# INNER WEST COUNCIL

7 November 2019

## **Powering Sydney's Future (SSI-8583) - Potts Hill to Alexandria transmission cable project**

Thank you for providing Innerwest Council an opportunity to comment on the Environmental Impact Statement for the project Powering Sydney's Future – Potts Hill to Alexandria transmission cable project

Figure 7 | Project Area – Route Options

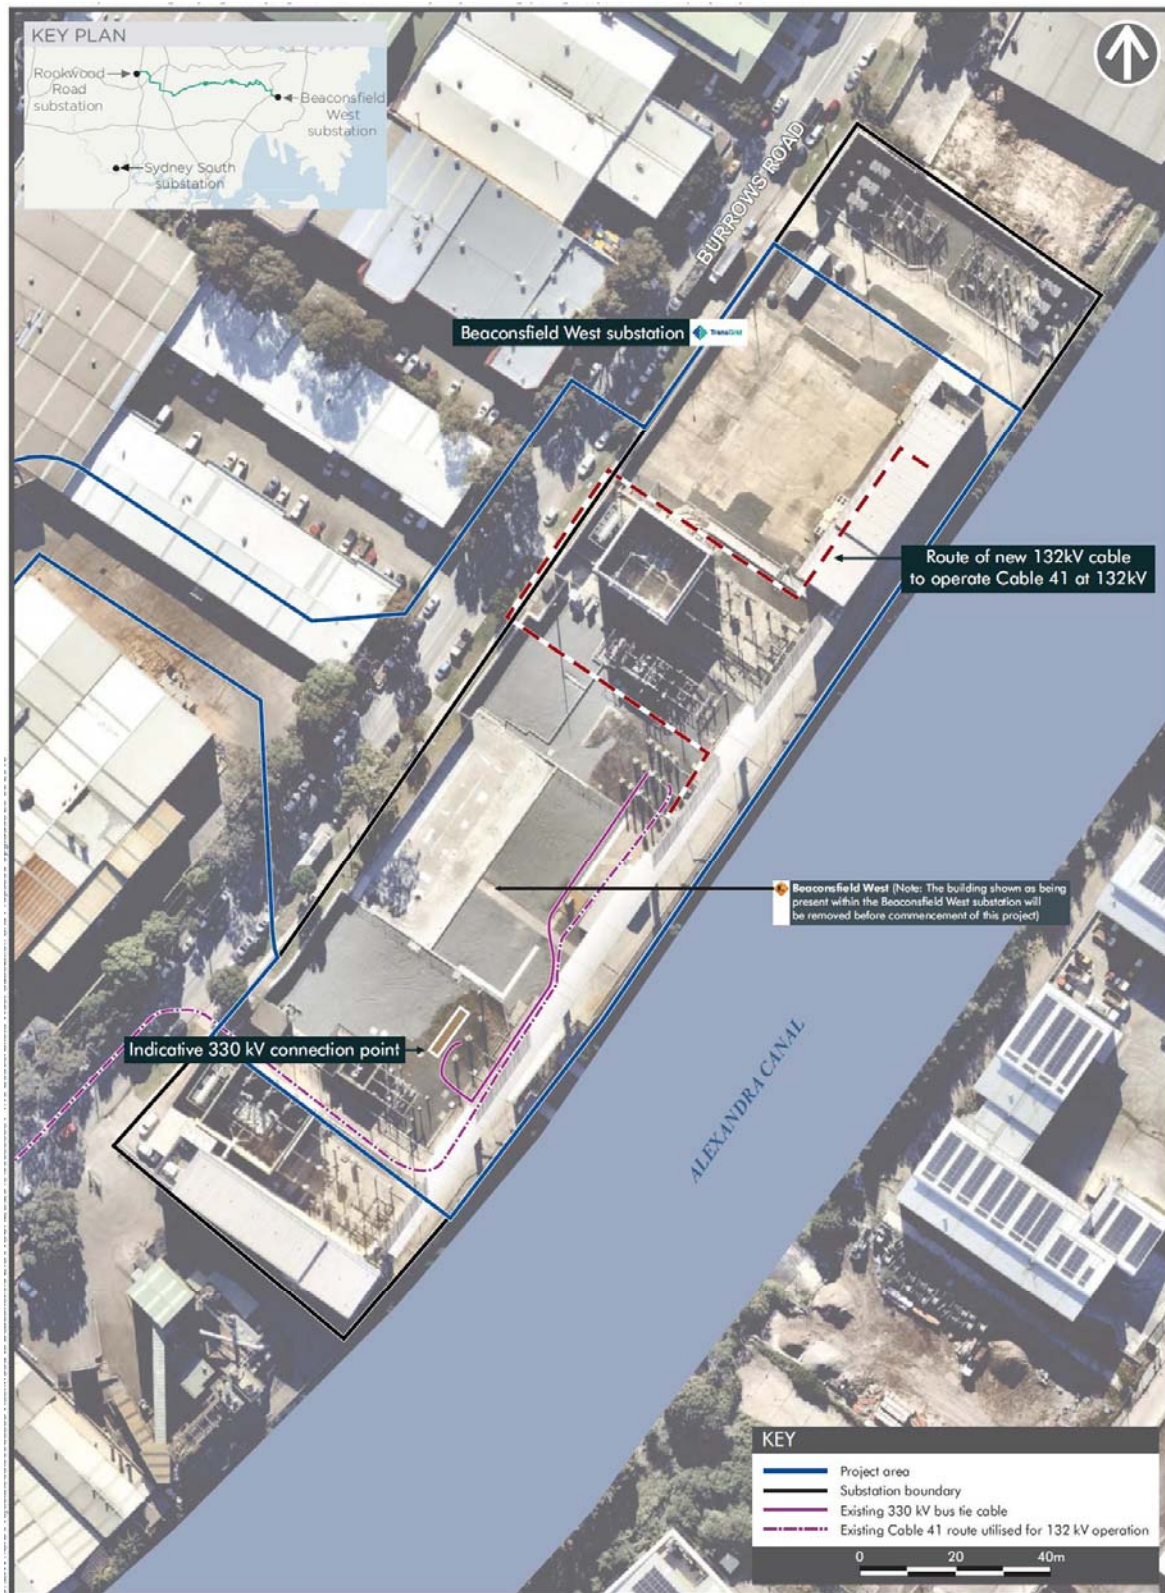
Route Option 5a in the vicinity of Henson Park is not supported due to potential impacts on playground equipment and shade structure footings and park surfaces of the proposed underboring. The proposed 'grassed verge' route location between the park and tennis club comprises a 3m wide fenced pedestrian corridor with centrally located 1.5m pedestrian path connecting Centenary Street and Amy

Street. The installation would require demolition and restoration of this path connection. Further information on location and depth of underboring, restoration and management of subsidence, park use and pedestrian impacts is required.

Concerns are raised in relation to route Option 4b in the vicinity of Johnson Park which includes underboring of Johnson Park due to potential impacts on play equipment footings and park surfaces. Further information on the boring methodology is needed.

Concerns are raised in relation to route option 4a due to its proximity to Green Way bush care site.
